PUDSP20007-R5-PDRFDR.pdf Markup Summary

EMERGENCY SPILLWAY CROSS SECTION B-B
SCALE: N.T.S.

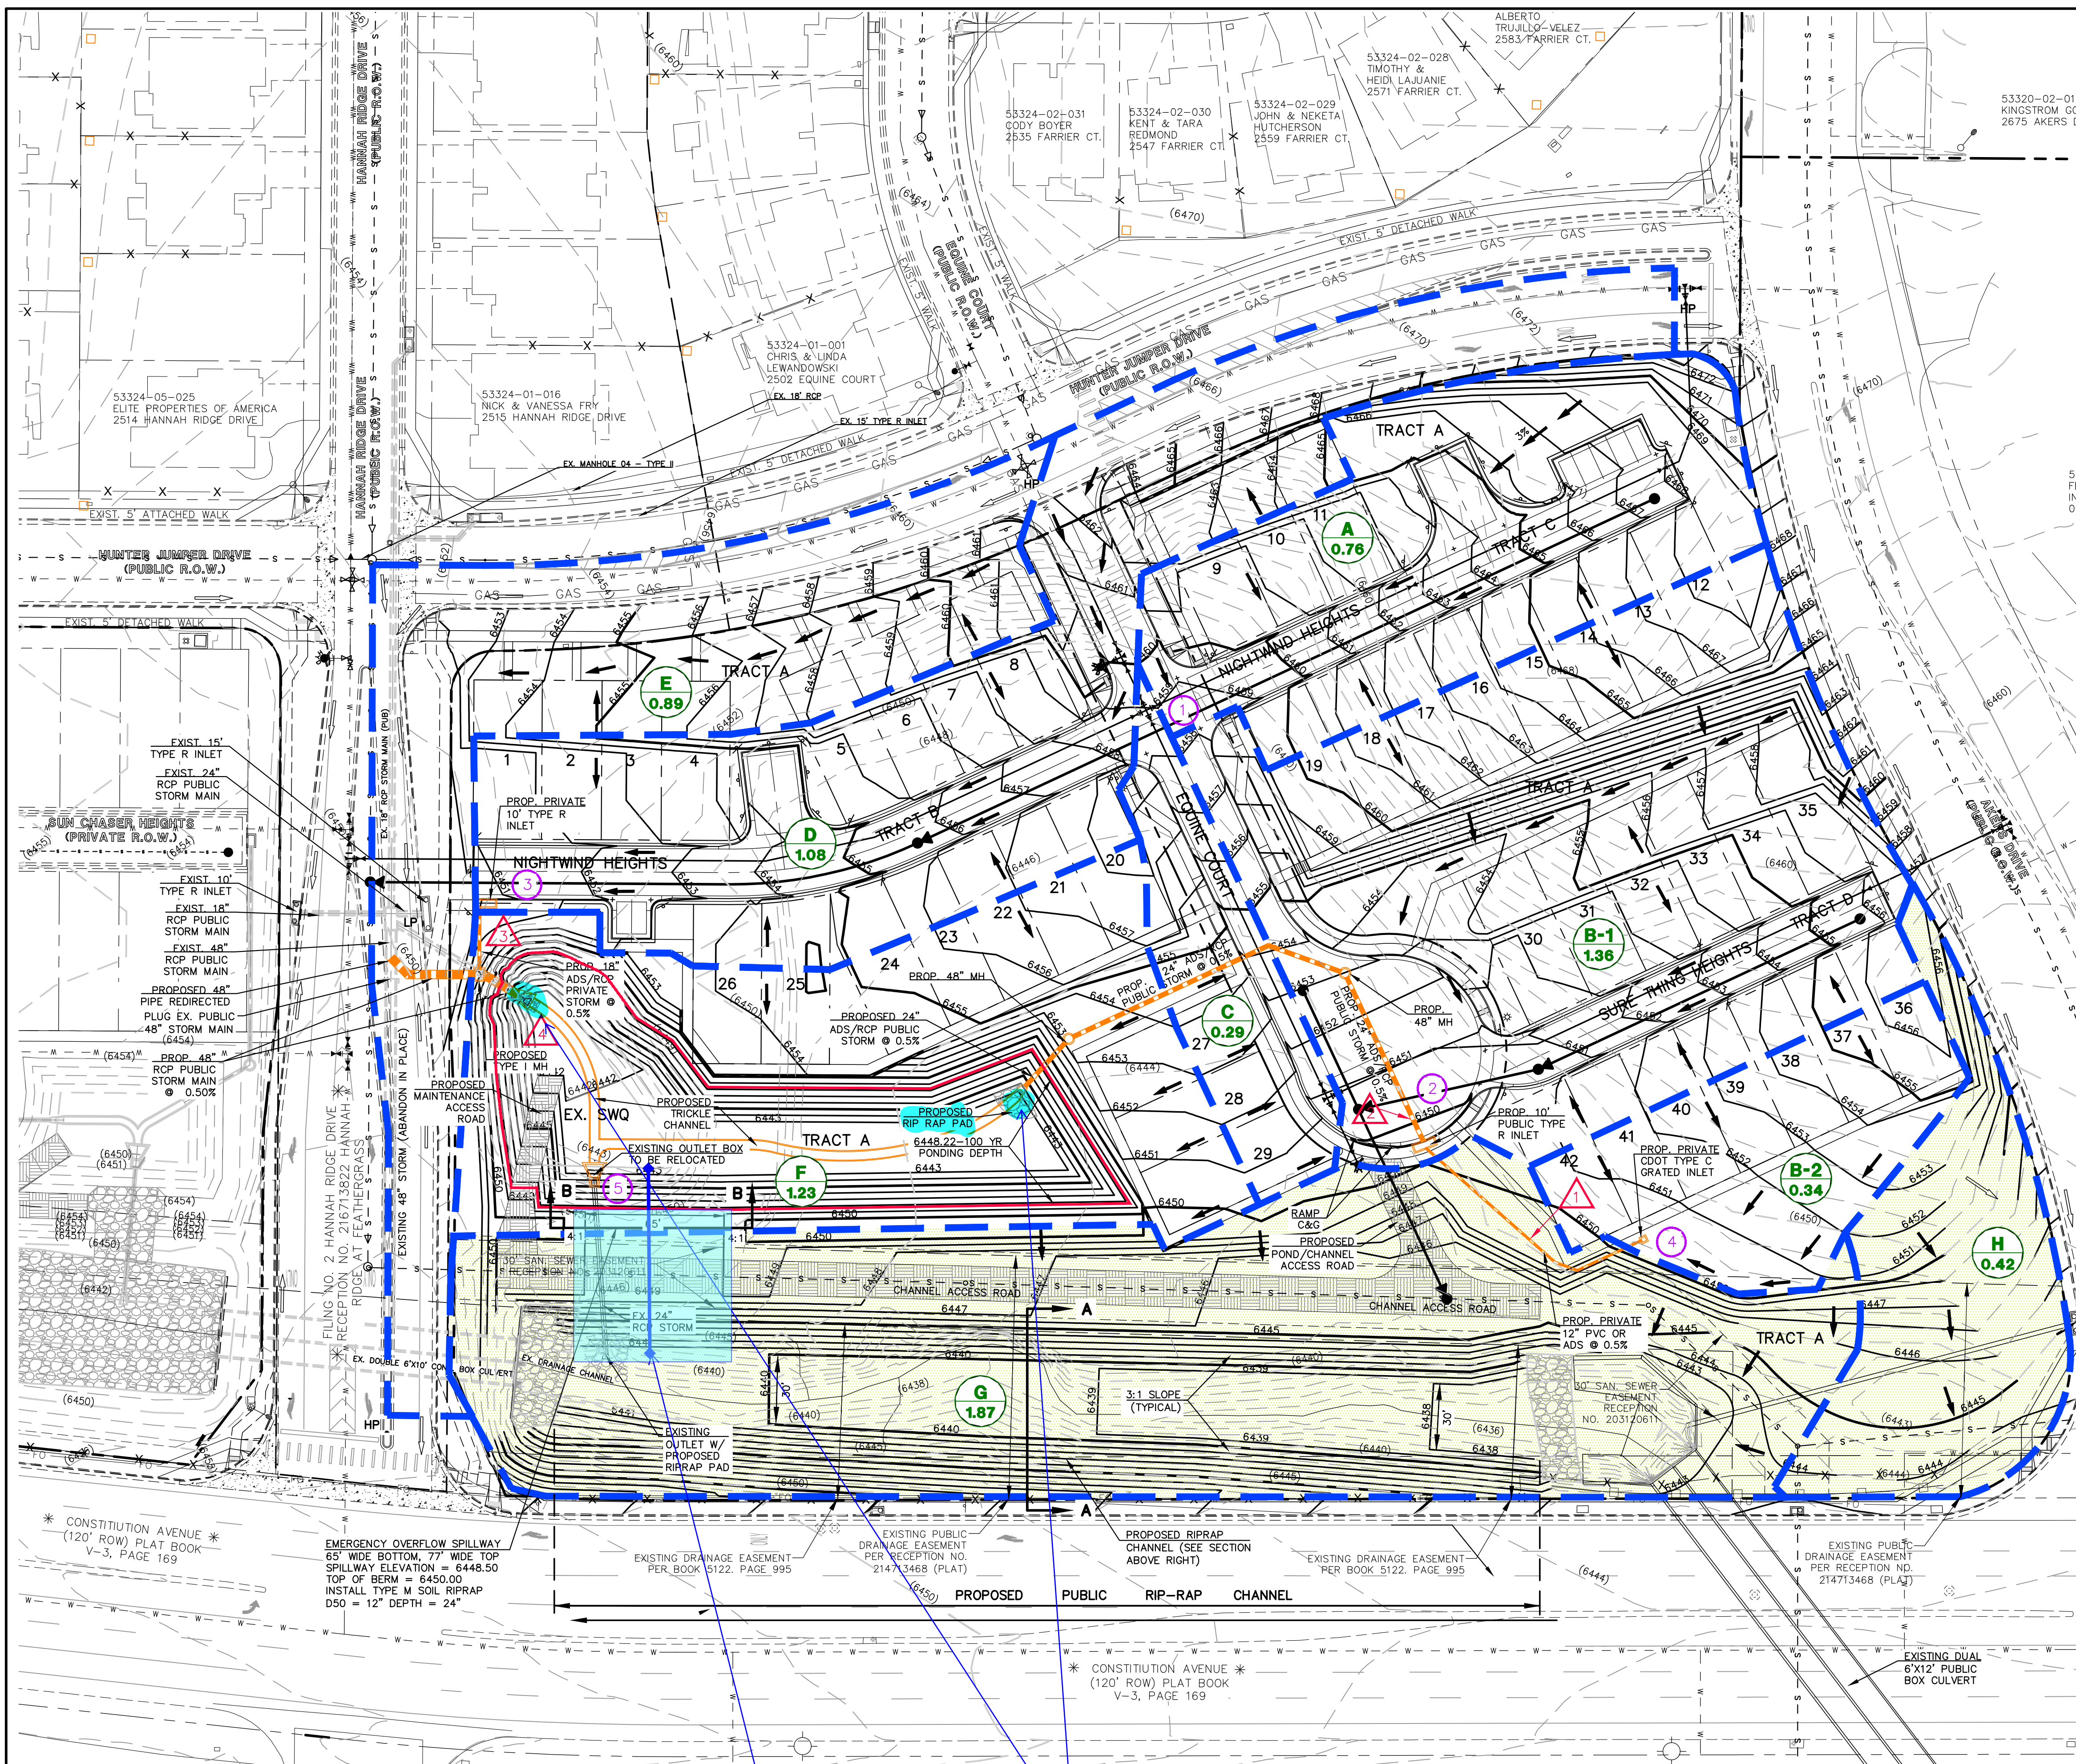
Show 100-year flow depth

Provide concrete forebays per report

Provide a north-south cross-section showing soil riprap to and protecting the outfall in the bottom of the channel
